**Our Case Number:** ABP-314501-22

**An  
Bord  
Pleanála**

**Date:** 13 February 2023

**Re:** South Dublin Street and Backlands Regeneration Project. The proposed development covers an area of approximately 2.72 hectares and comprises urban regeneration and public realm proposals. Properties at 7- 13 Dublin Street, lands to the rear of 1-9 The Diamond and 1-26 Dublin Street, the Courthouse car park, Lower Courthouse car park, Castle Road, and N54 Macartan (Broad) Road, townlands of Roosky and Tirkeenan, Co. Monaghan

**MGT0528-
RPS-00-XX-
DR-C-DR1001
- Drainage
(Planning Issue)**

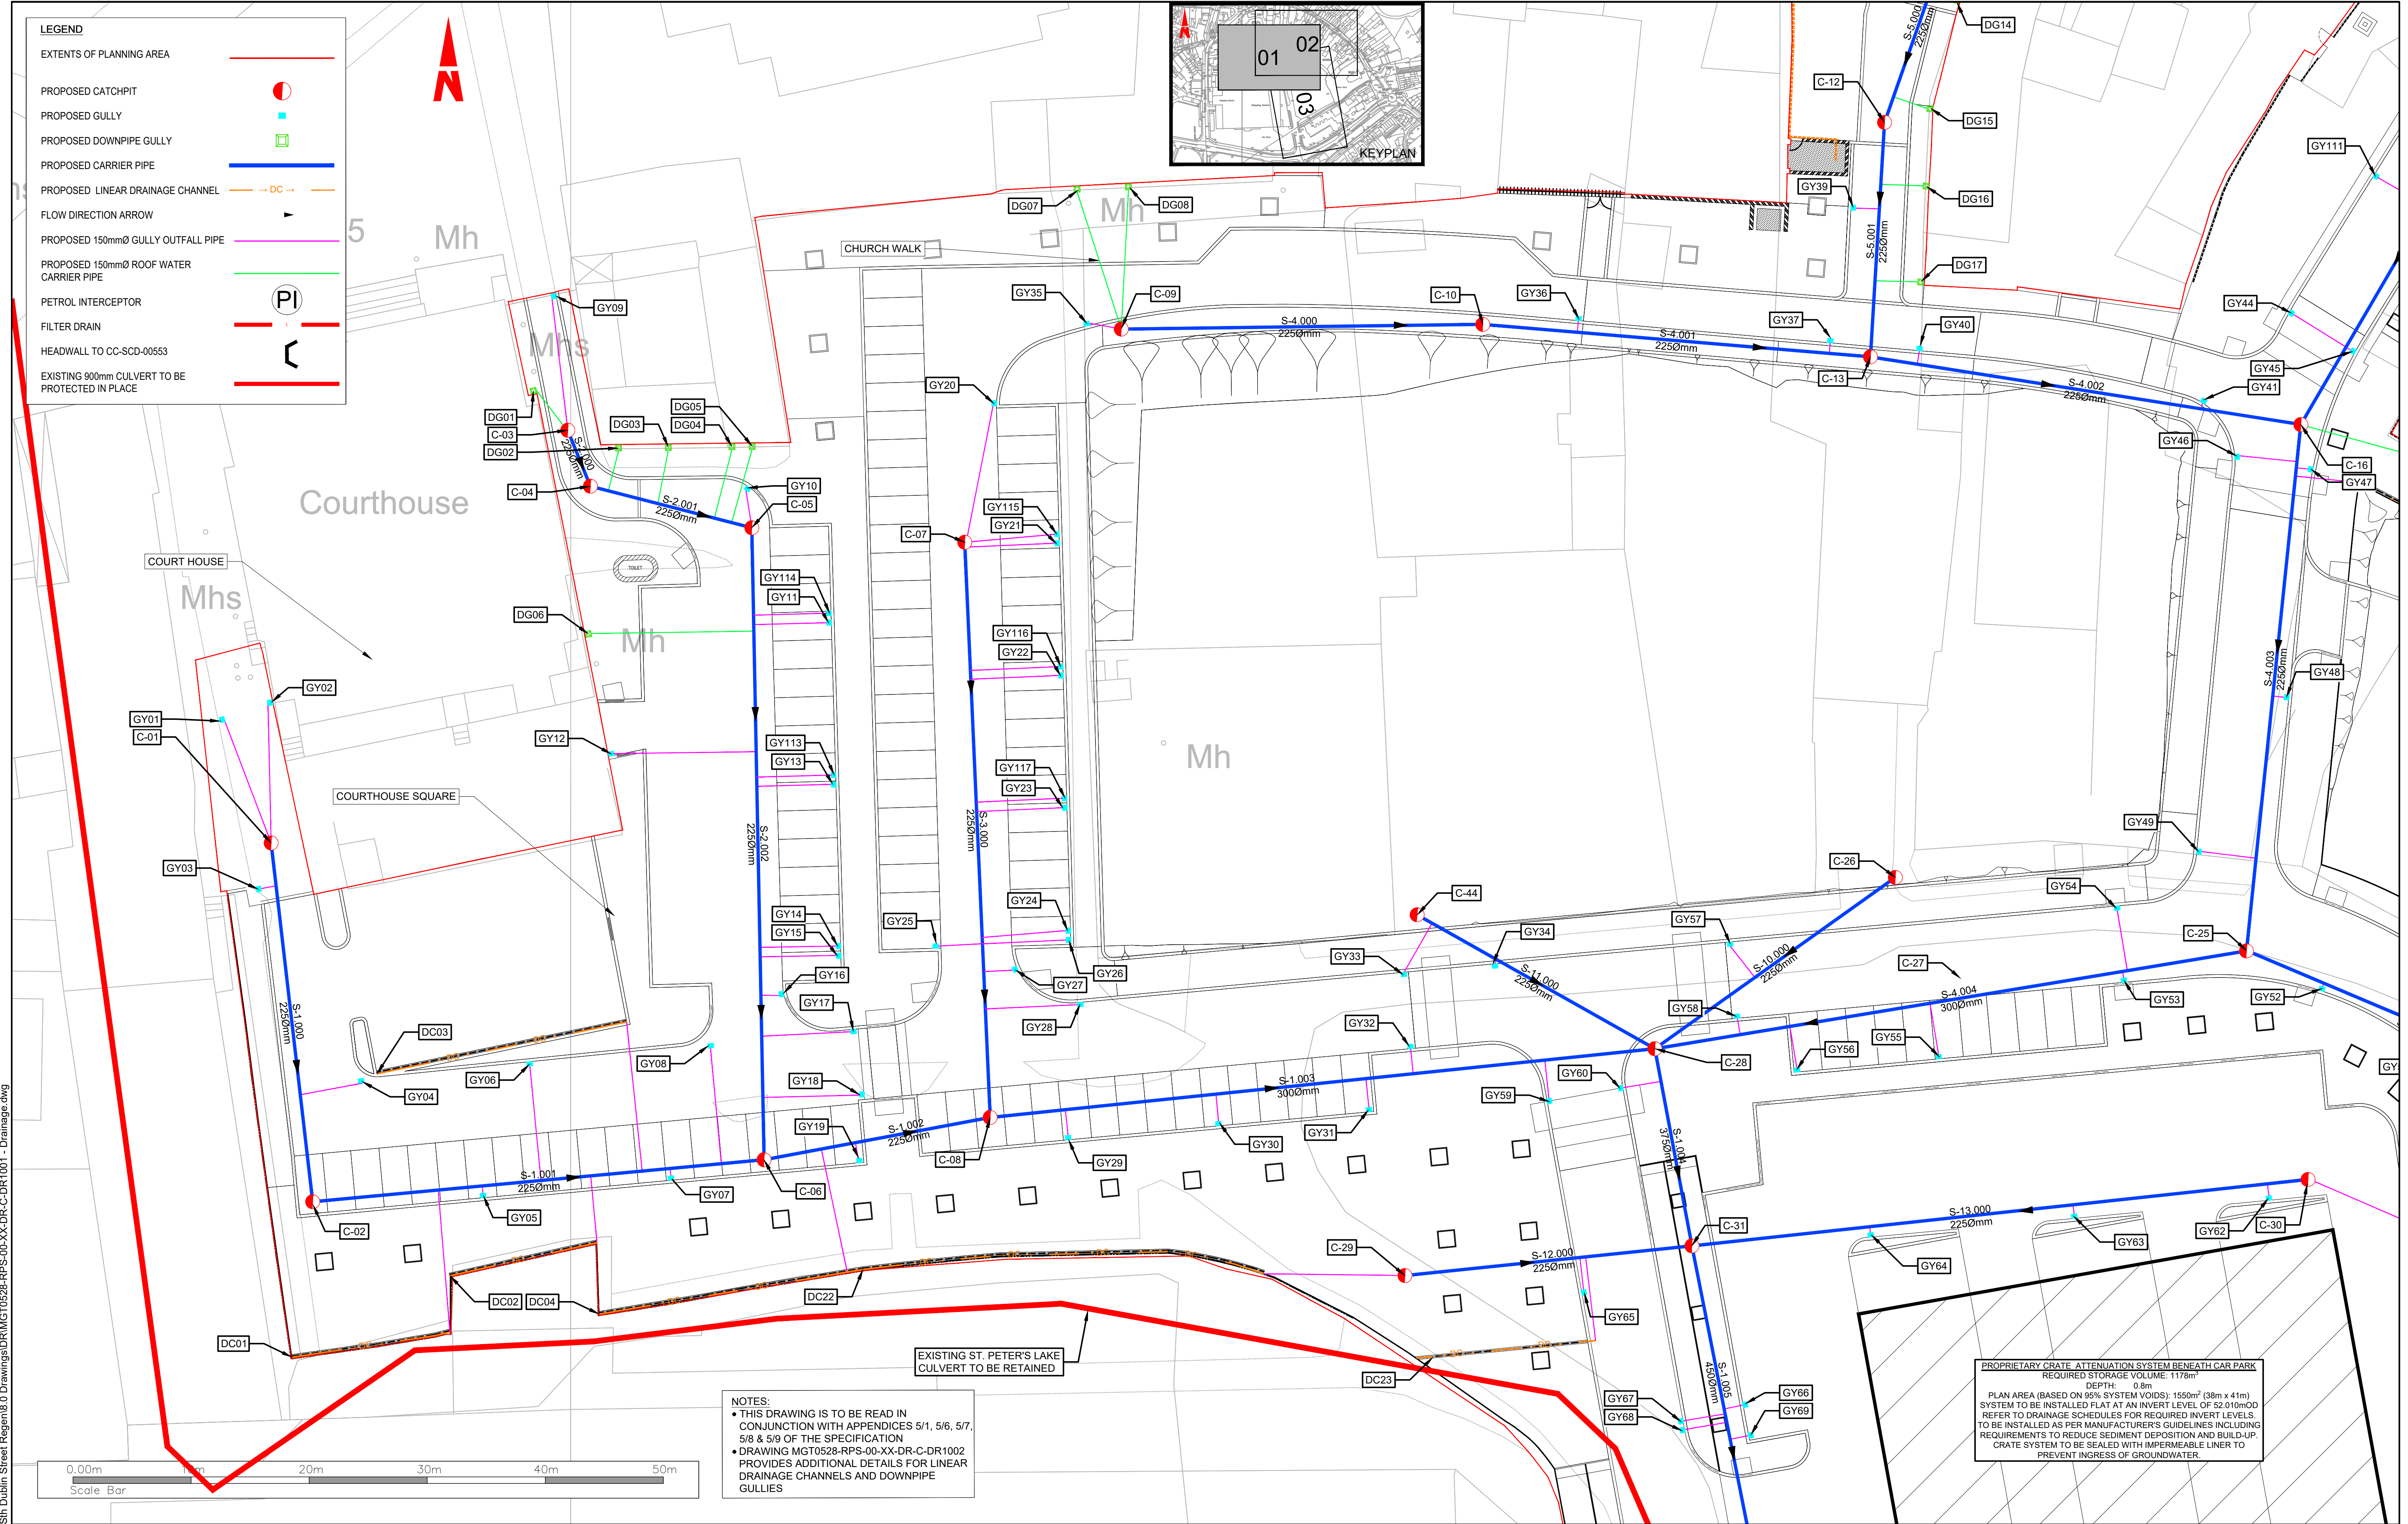
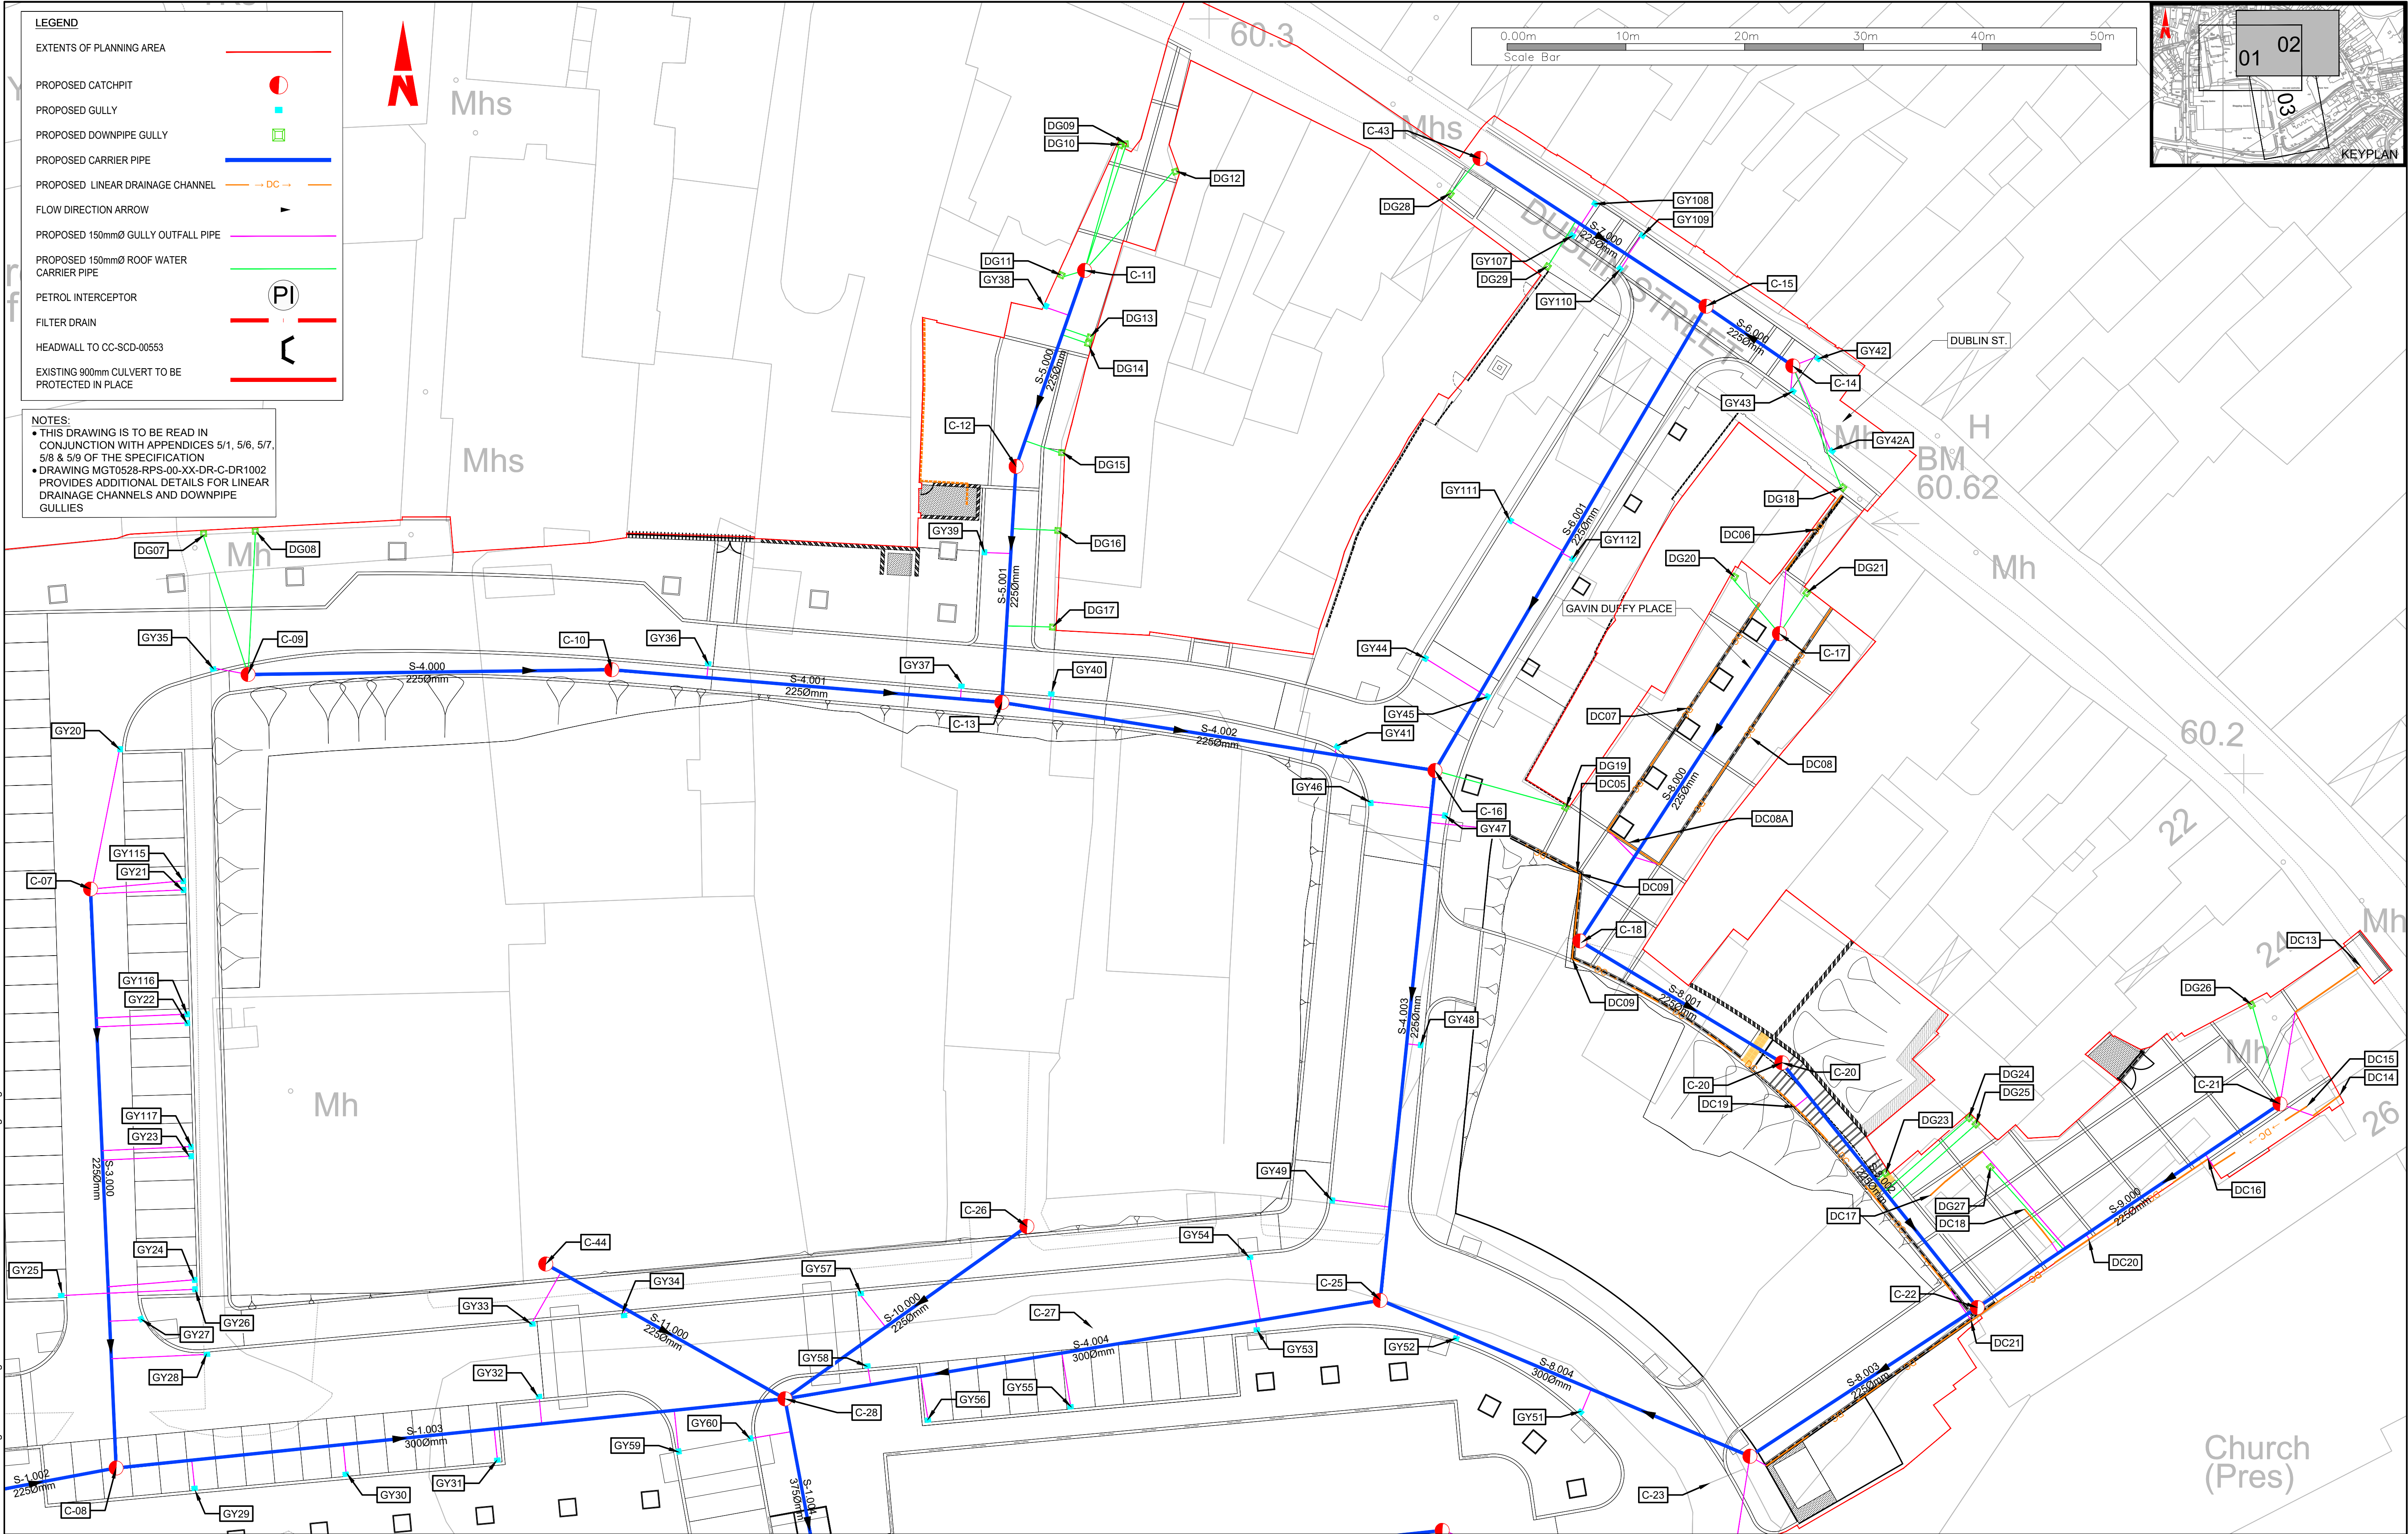
- (a) Table 6.8 is a repeat of Table 6.9: summary of Ortho-Phosphate. Please submit the correct Table 6.8 Summary of Total Oxidised Nitrogen, and include a statement as to whether or not the levels are indicative of high or good quality or otherwise.
- (b) The Drainage Layout Map, drawing no. DR1001 does not indicate the proposed water or sewerage network. Please submit a site layout plan detailing these proposed networks.
- (c) Submit a site layout plan indicating existing service networks in the site, to include water and sewerage.
